Application No: 20/03192/DISC

Proposal: Discharge of Condition 25 (Phasing), Condition 36 (Construction Management Plan), Condition 37 (Construction Environmental Management Plan for Biodiversity), Condition 38 (Tree Protection), Condition 39 (Training and Employment Plan) and Condition 45 (Site Access) and Partial Discharge of Condition 40 (Sustainable Drainage) and Condition 46 (Estate Roads, Parking and Turning Areas) of 19/01740/HYBRID

Location: Land Adj To Promised Land Farm, Wendlebury Road, Chesterton

Transport Development Control

SECTION 278 WORKS
BICESTER AVE ENTRANCE WORKS

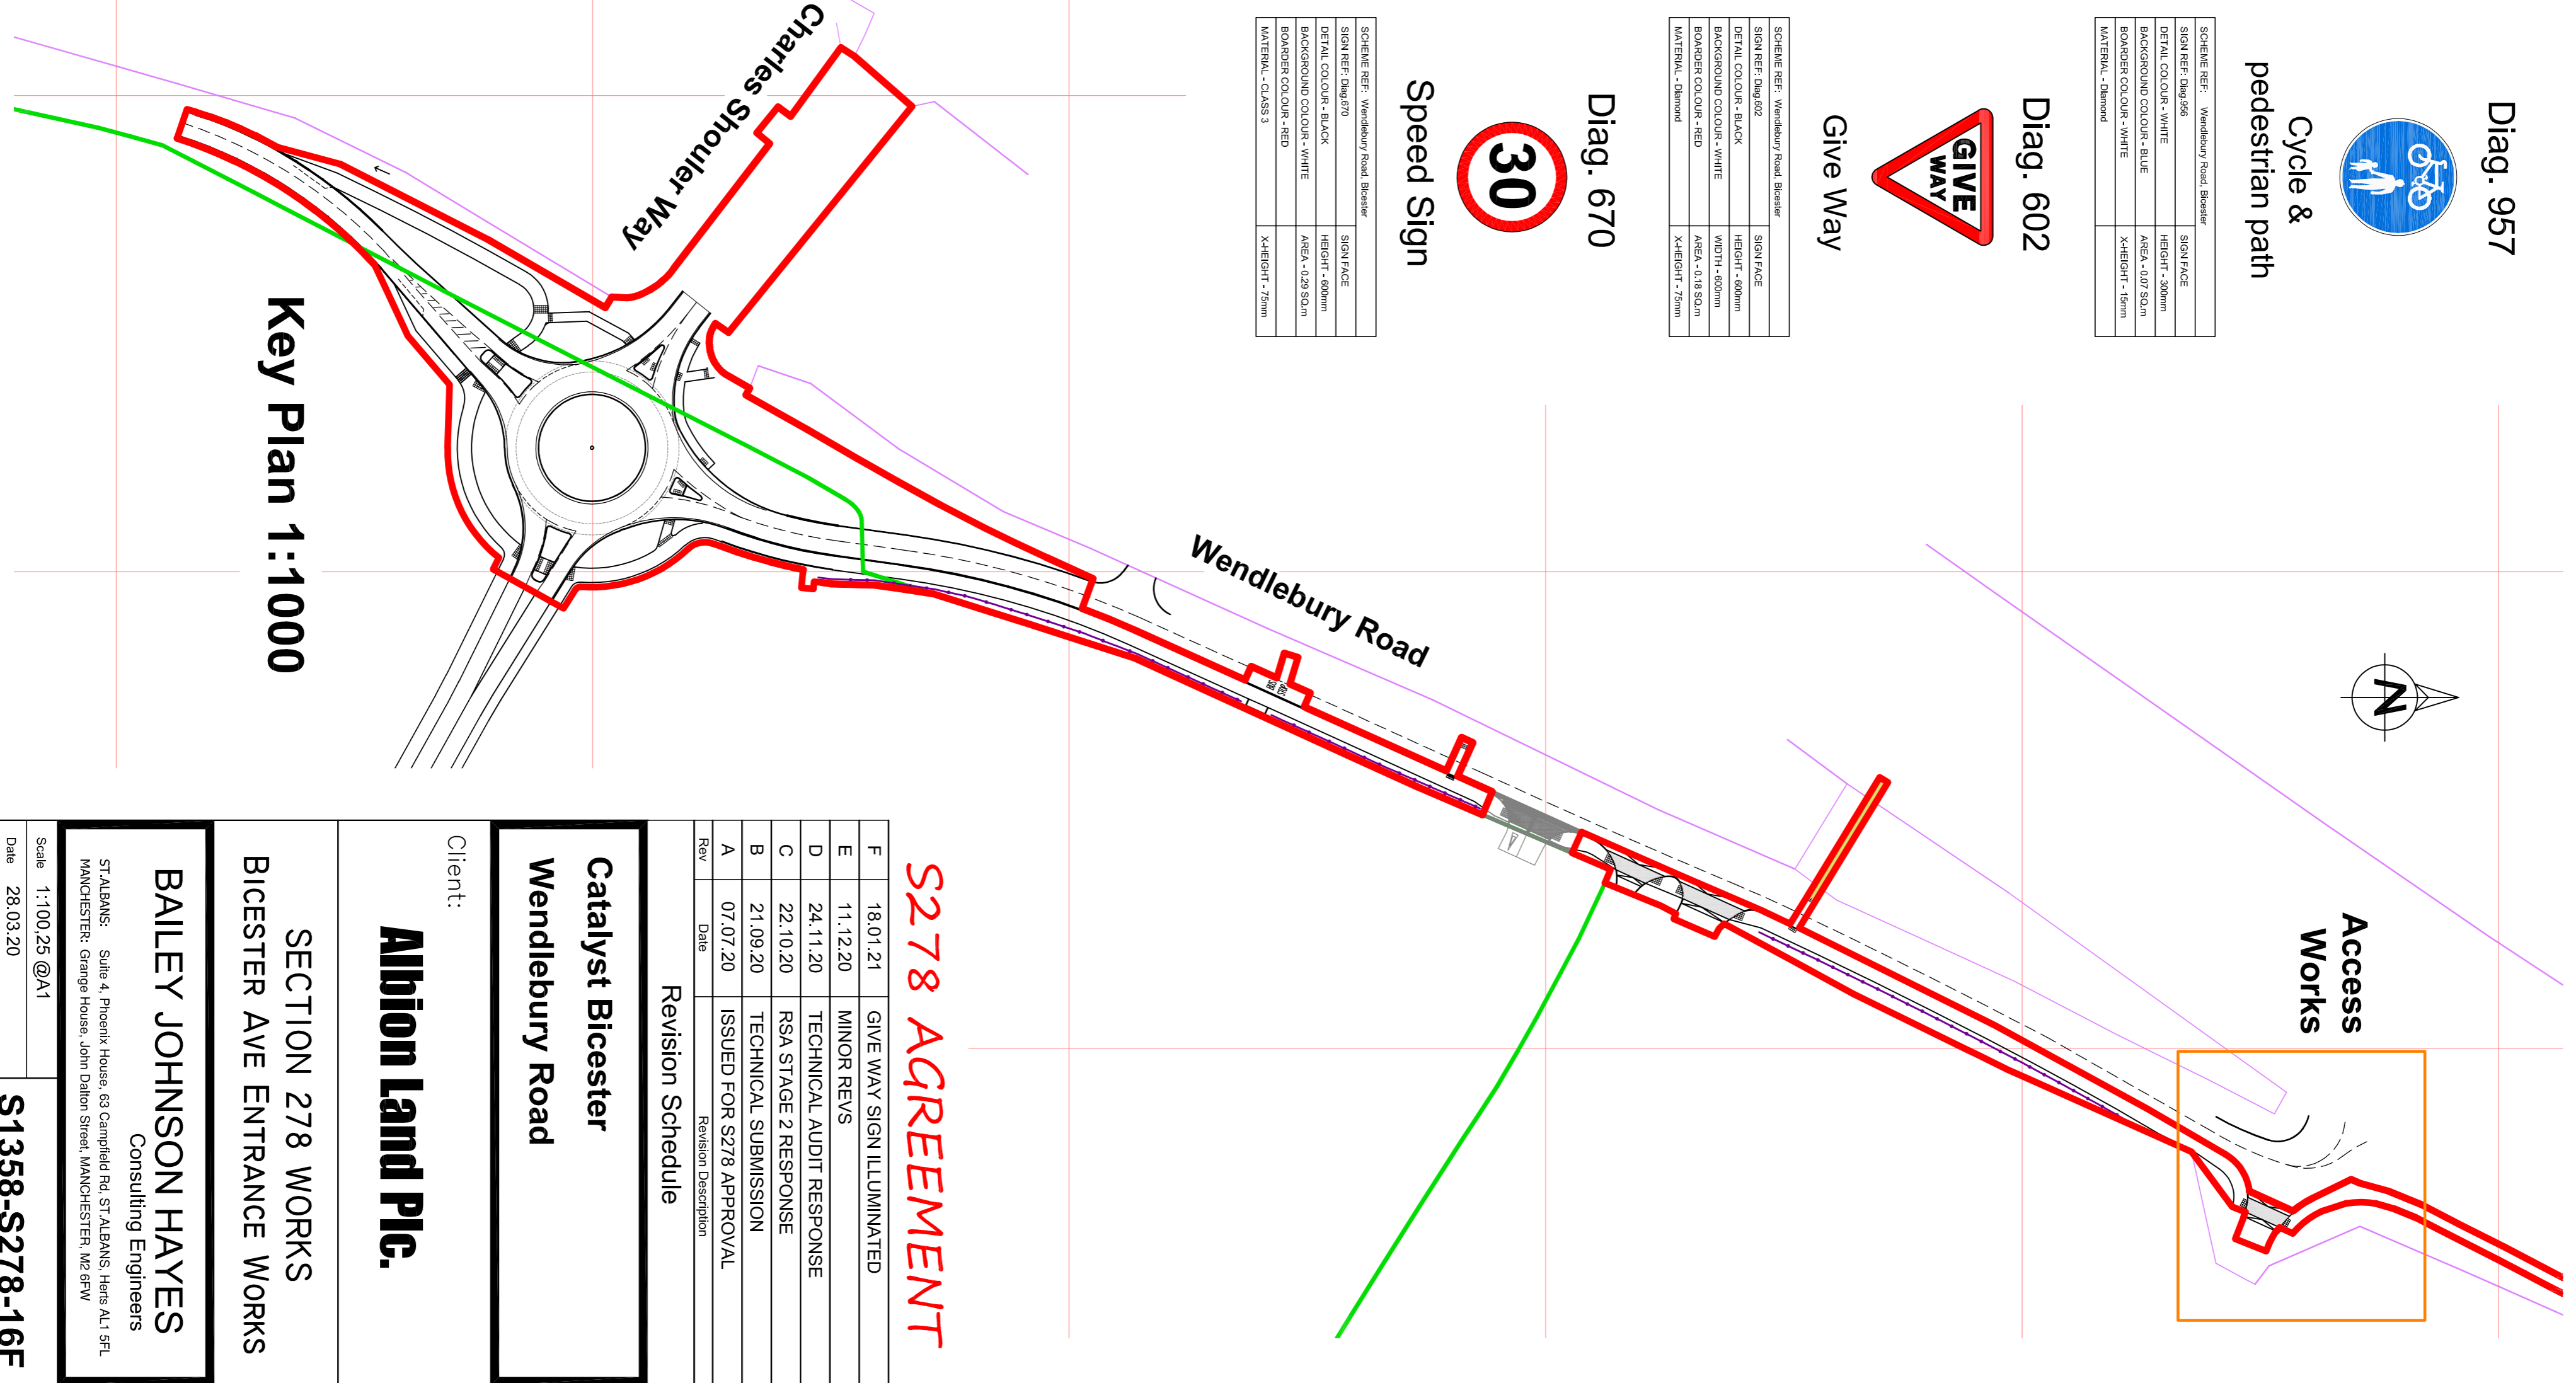
Access plans show the primary road to be flanked by a 3m shared footway/cycleway on the southern side while the northern side is a 2m footway. This arrangement is considered to only be satisfactory for vehicles and pedestrians but does not adequately cater for cyclists, requiring them to use indirect routes that are less convenient. It is seen that cyclists from Wendlebury Road (N) on a 3m shared facility would be in a limbo when the shared facility does not extend into the site, bringing confusion on how they would proceed into the development. It would be preferable to extend a similar width into the site that caters for both pedestrians and cyclists. Other than that, a cycle lane (advisory) needs to be introduced on the access road including an appropriate transition for them to merge onto the carriageway, like those proposed on the merge onto/from Wendlebury Road (S)carriageway.
